TRANSPORT ASSESSMENT ADDENDUM

Project:	Land off Ploughley Road, Ambrosden, Oxfordshire – 22/02866/OUT	Page 1 of 6
Subject:	Site Access Arrangements	Date: 10/01/2023

Technical Note Prepared by:	Approved for Issue by:
Christopher Miles Transport Consultant	Max Thurgood Director

Project	Originator	Volume	Level	Type	Role	Orig No.
B05927	CLK	XX	XX	DR	C	0007
Scale	1/250 & 1/100 @ A1	Date	20.07.2022	Revision	P05

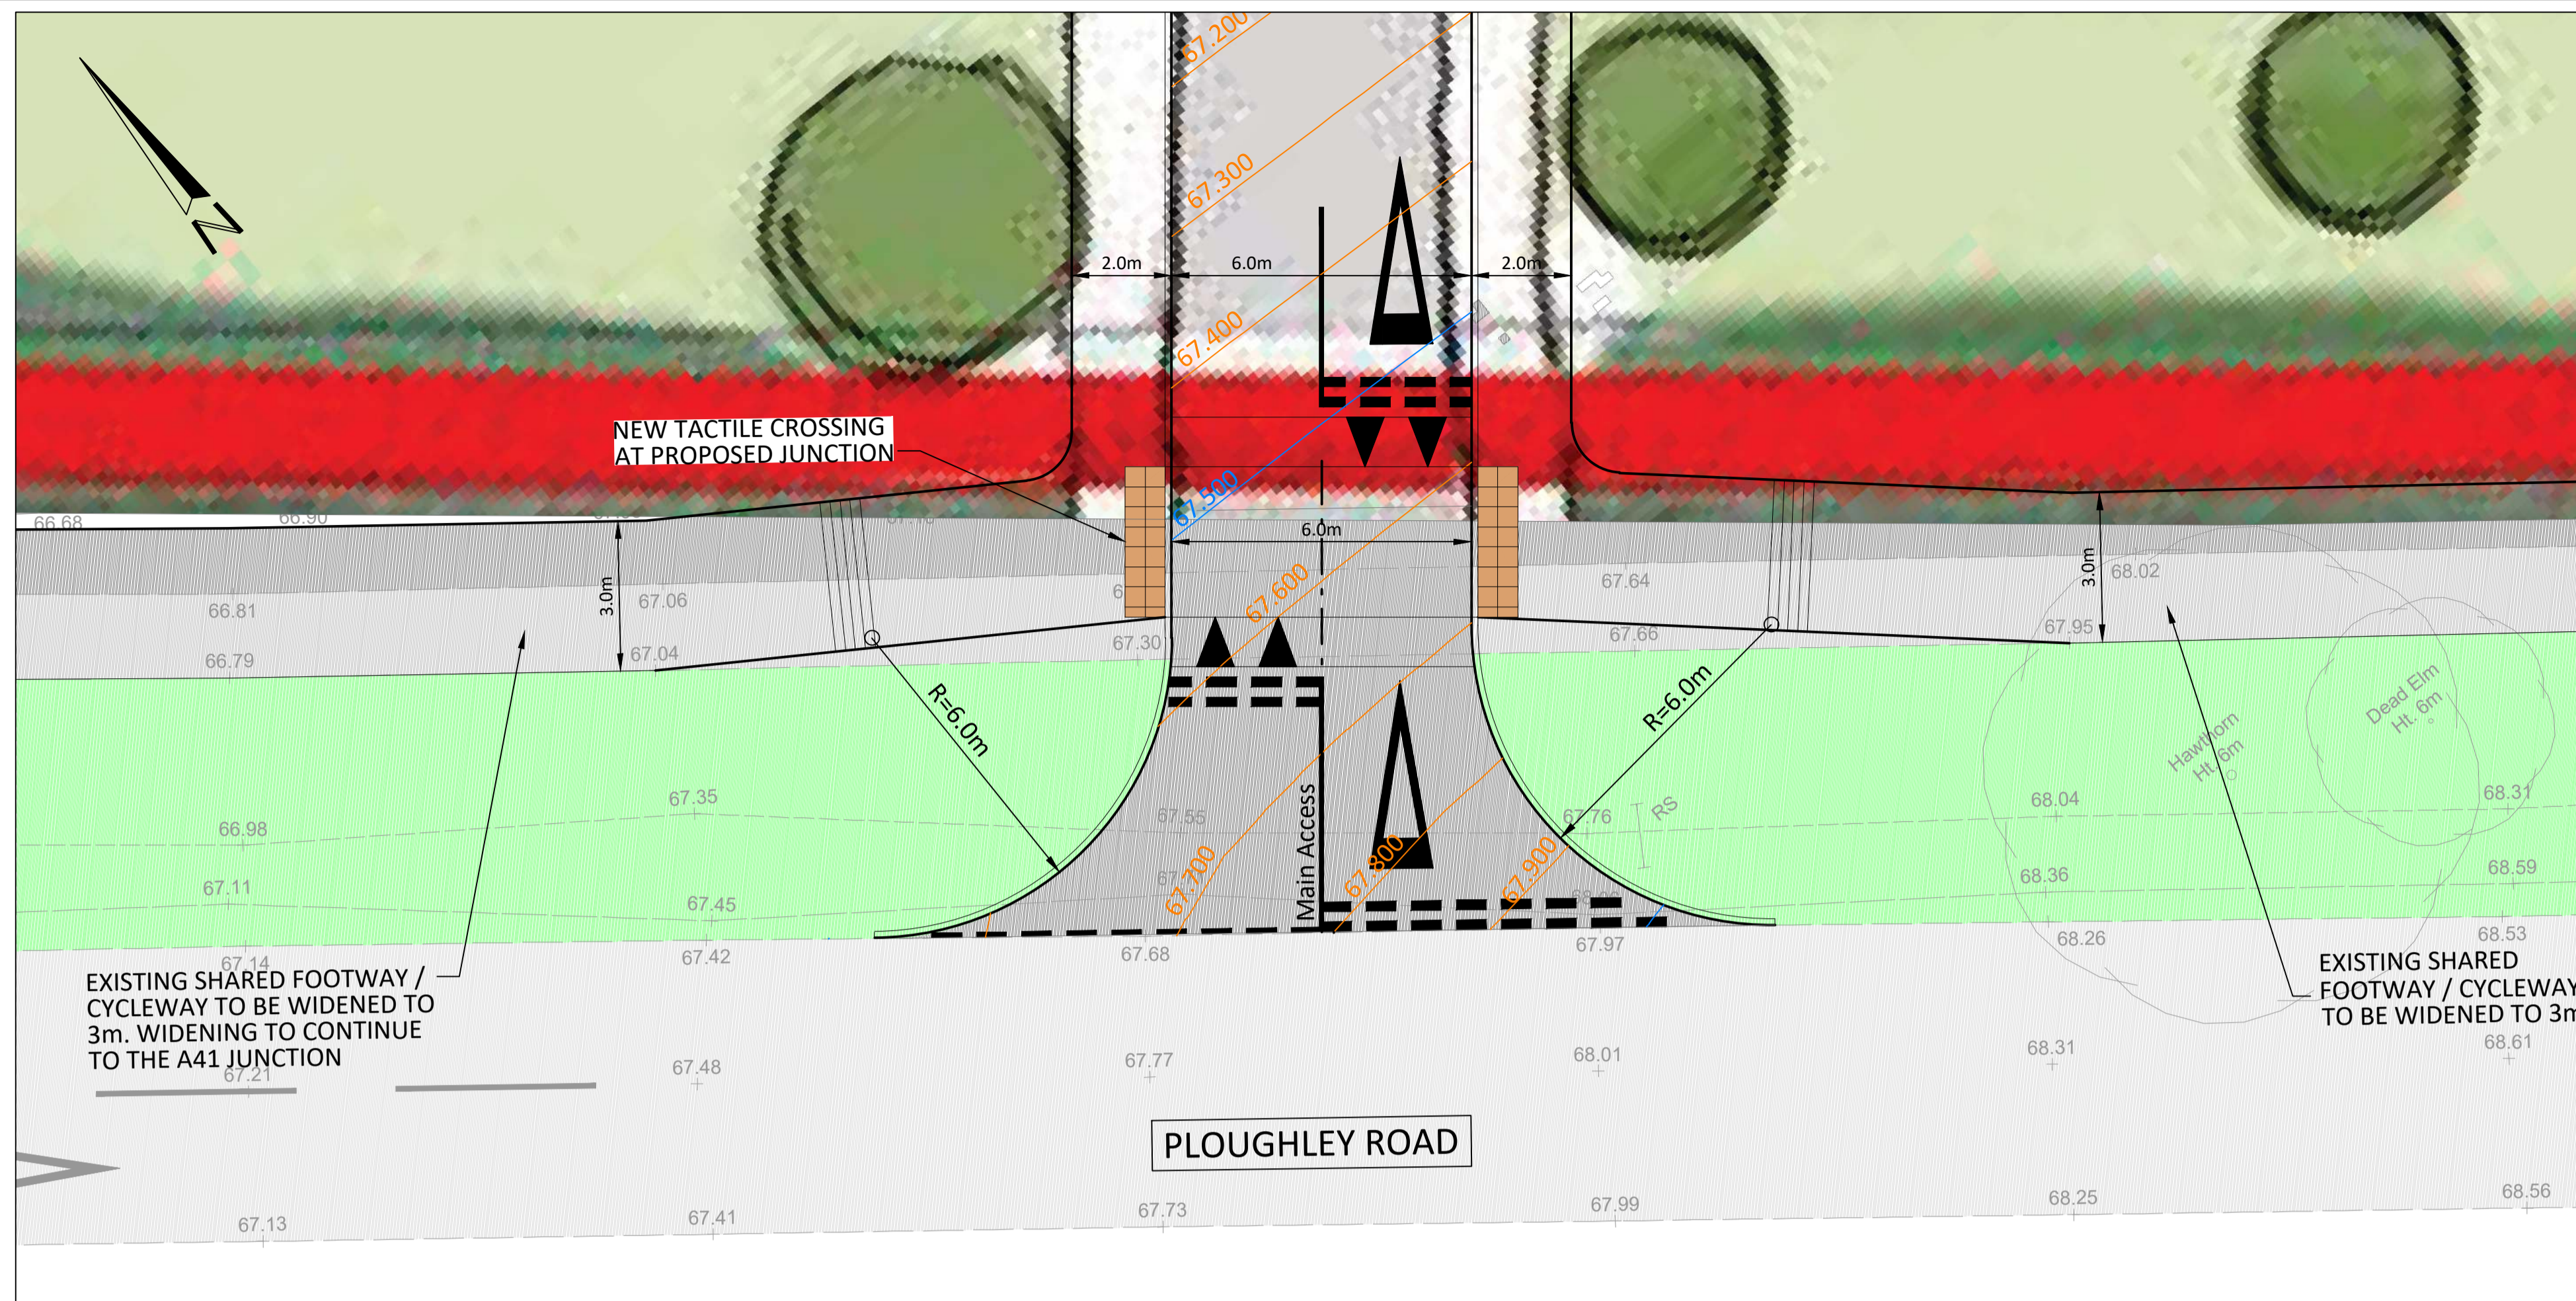
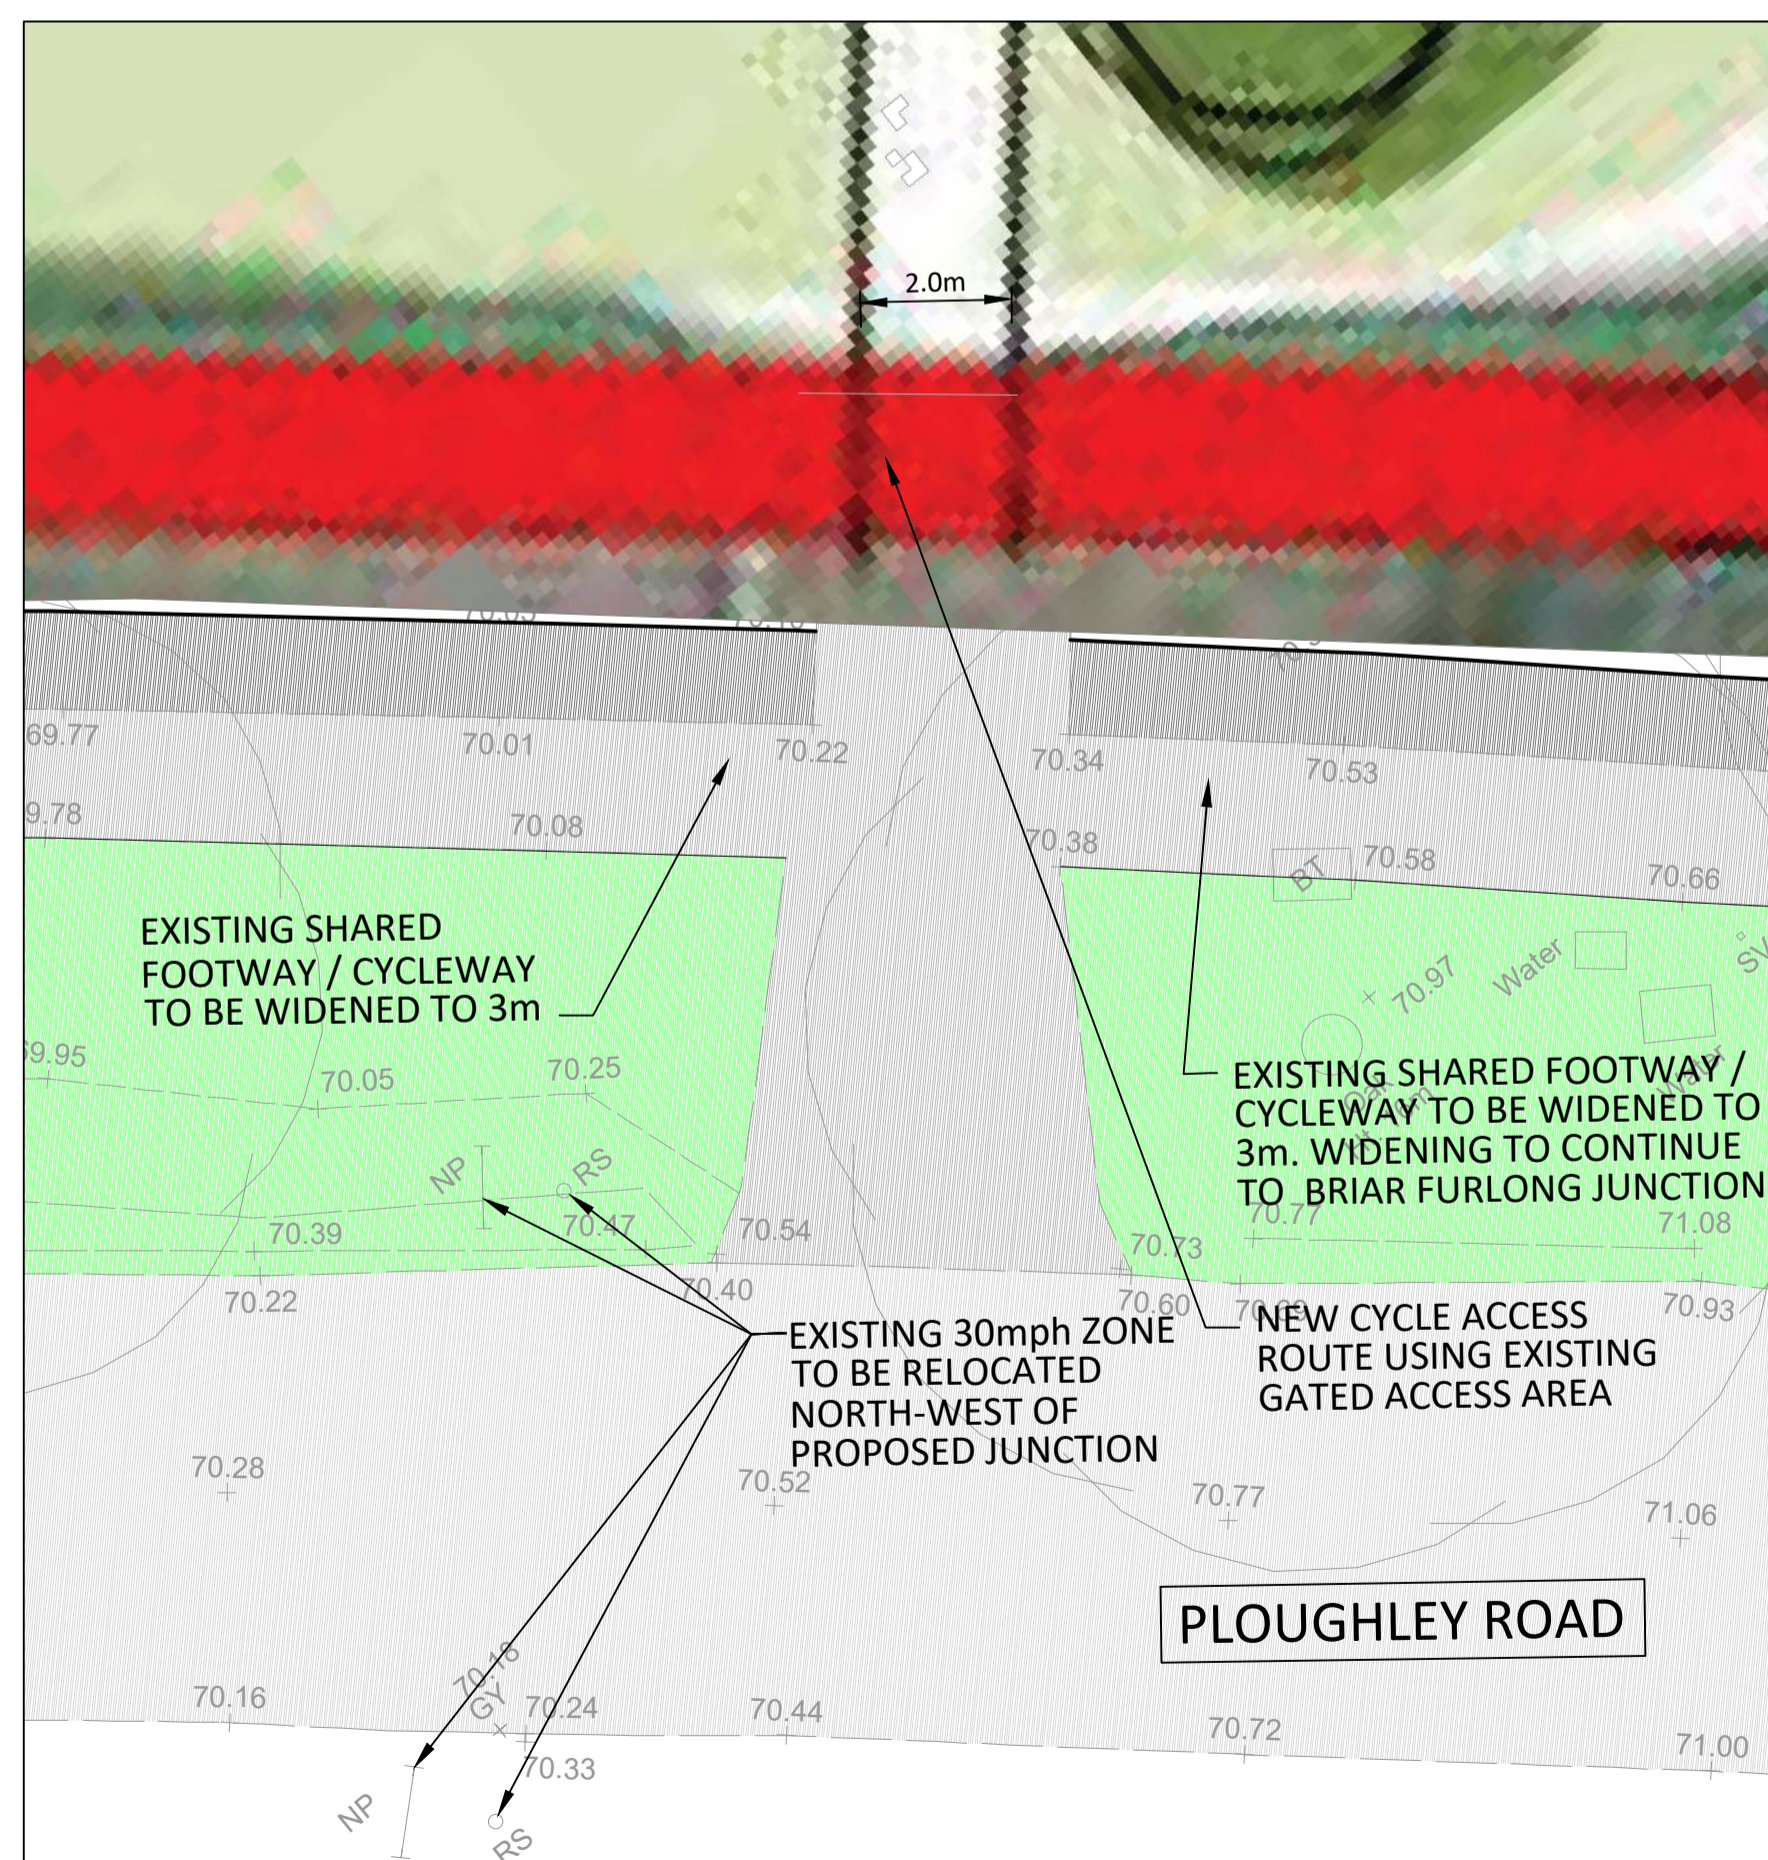
The OCC consultation response also identifies that the bellmouth access junction must include a cycletrack crossing in accordance with Local Transport Note 1/20: Cycle Infrastructure Design. The layout of the access junction has therefore been amended to give greater priority to the existing shared use path where it crosses the proposed site access (plan 0007_P06 in Appendix B).

The path is shown as being widened to 3m where it crosses the access road and slightly realigned into the site to increase the offset distance from the Ploughley Road kerb line to approximately 6m. This in turn allows the introduction of a raised table to give pedestrians and cyclists using the shared use path priority over vehicles entering and departing the residential development. This can also be reinforced through the provision of formal ‘give way’ road markings on the site access.

This arrangement complies fully with the LTN1/20 design guidance including the provision of appropriate car driver to cycle path visibility splays in both directions.
